East Preston Parish Council
Mr Simon Cross
Council Cabin
Sea Road
East Preston
BN16 1LP

15th December 2008

Single storey front extension
28 Meadow Park East Preston

DRAWING: 0820/01

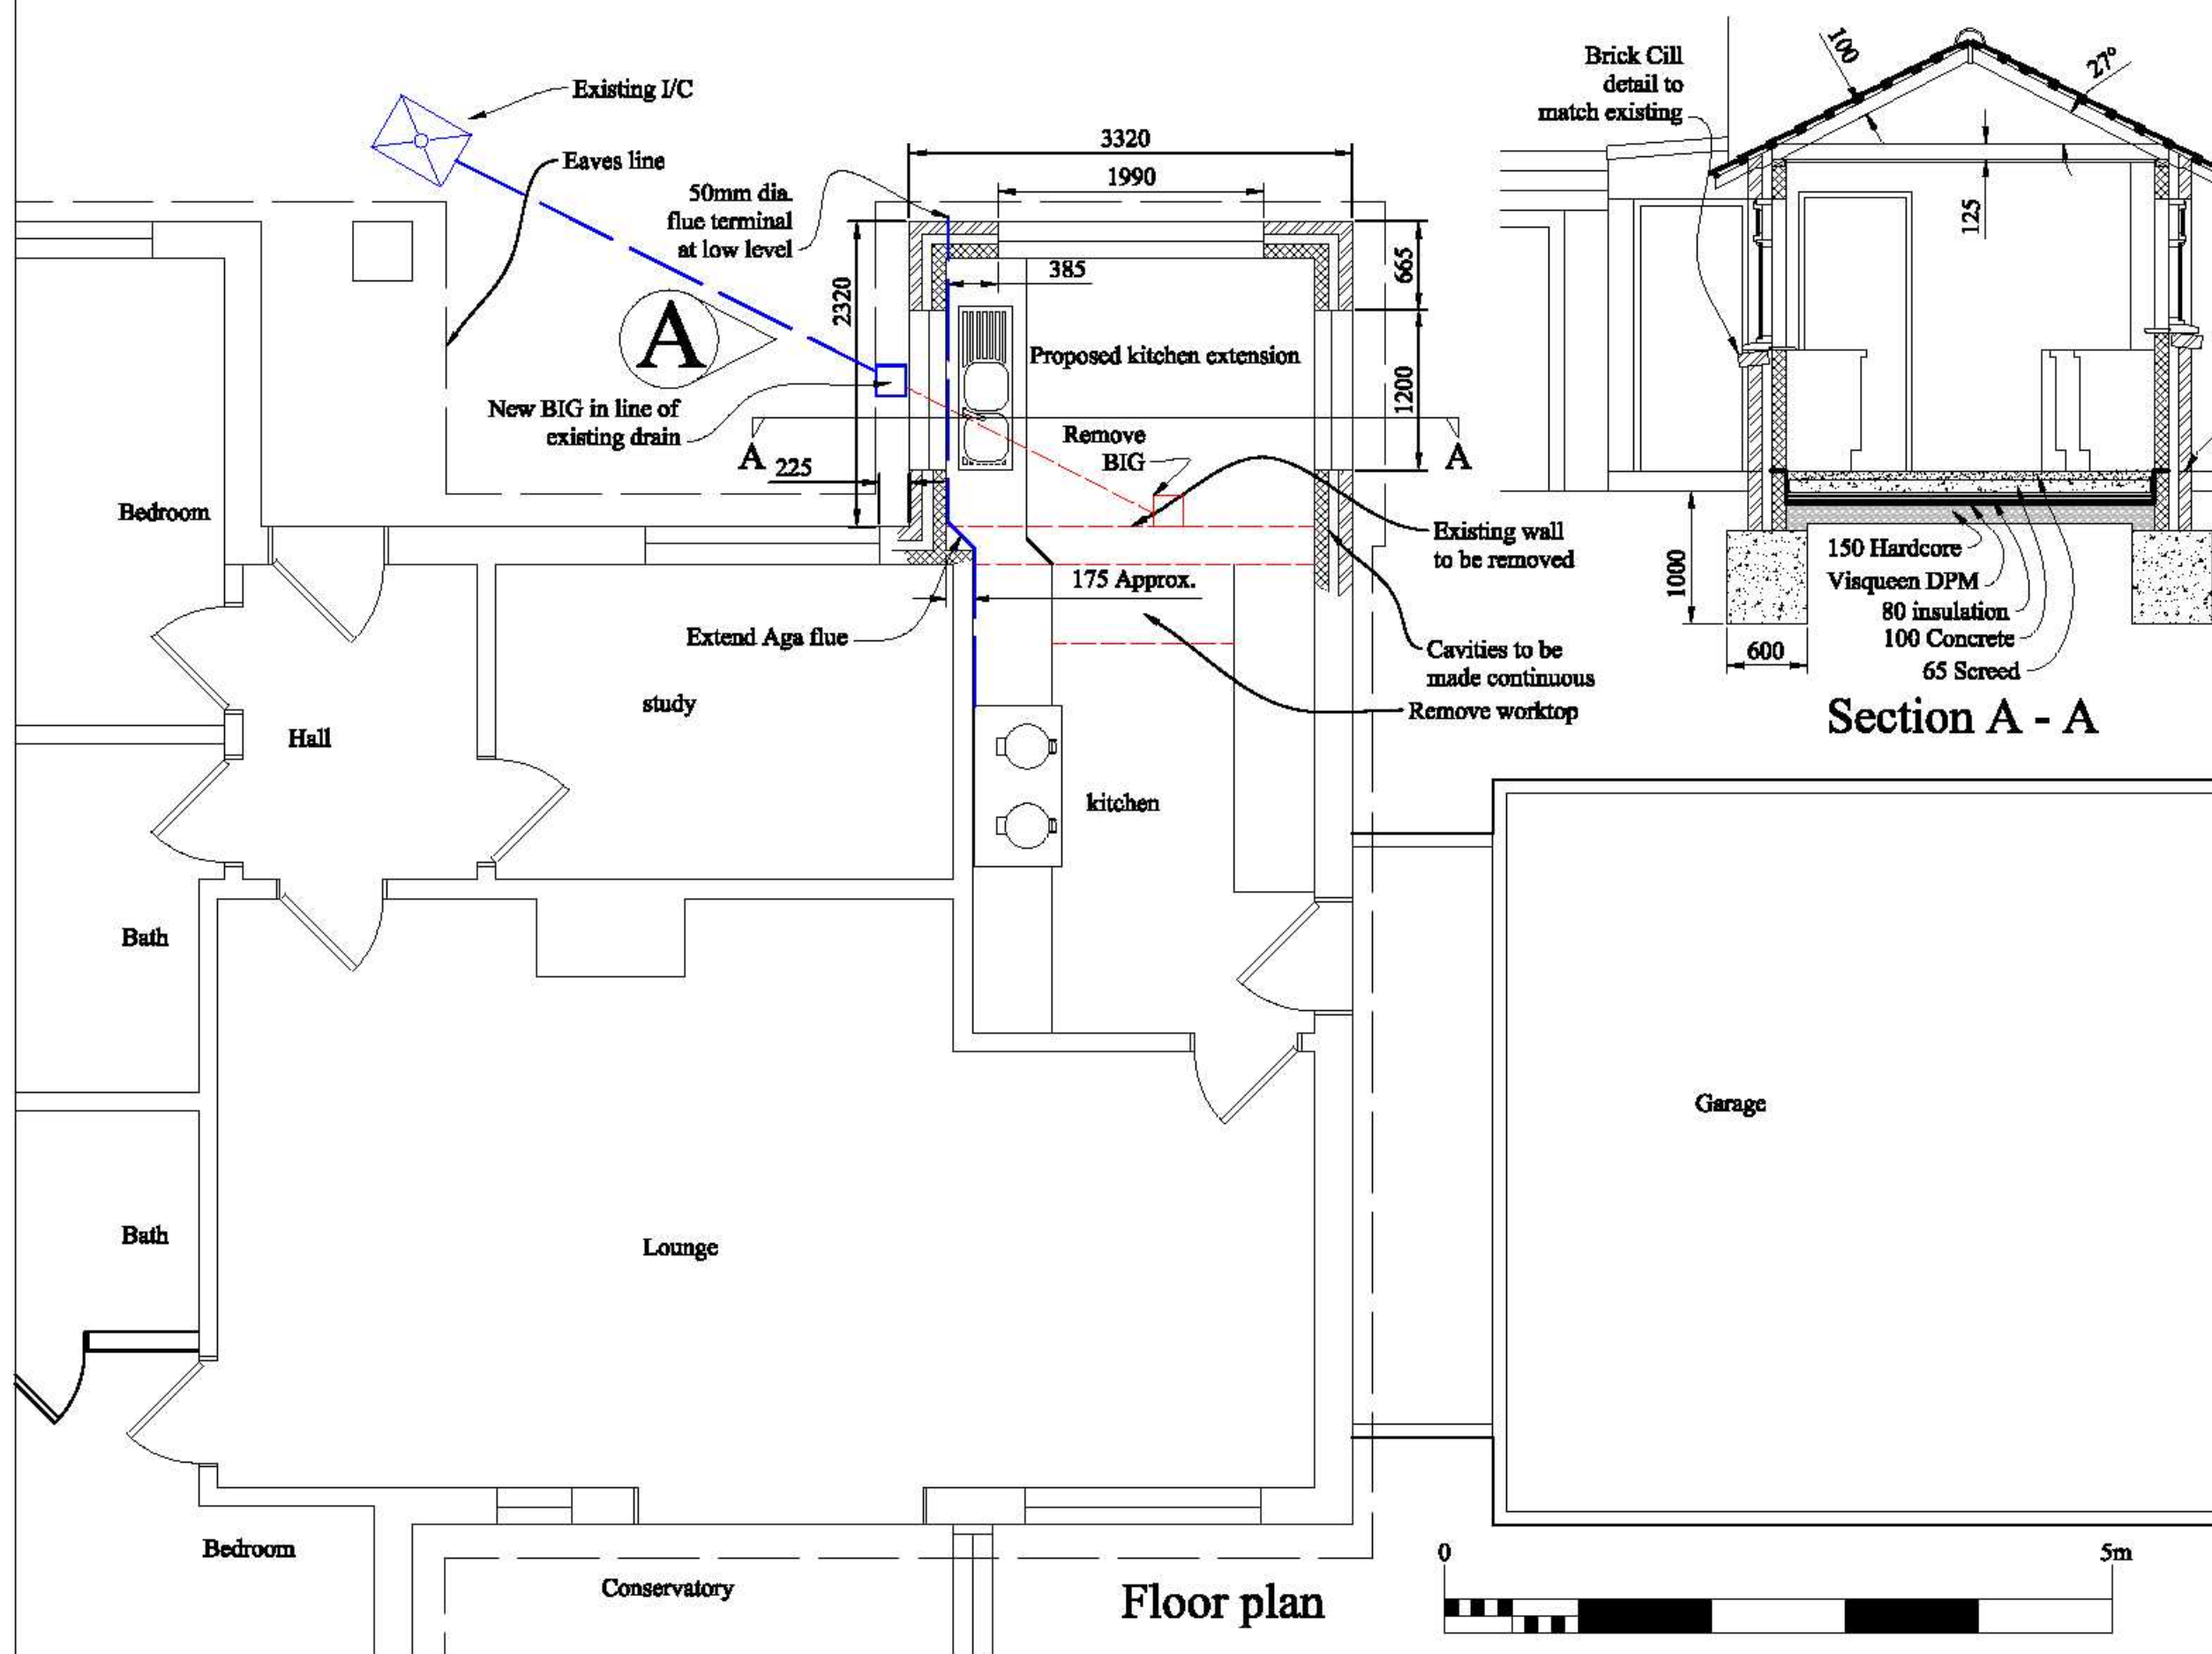
The Committee NOTED the numbering on the two plans did not match. The site plan referred to the plot as No.17 whereas the actual plan was No. 28. ☐

The Planning Committee had no objections to raise against this Application but would bring to the attention of ADC that the numbering was not consistent. ☐
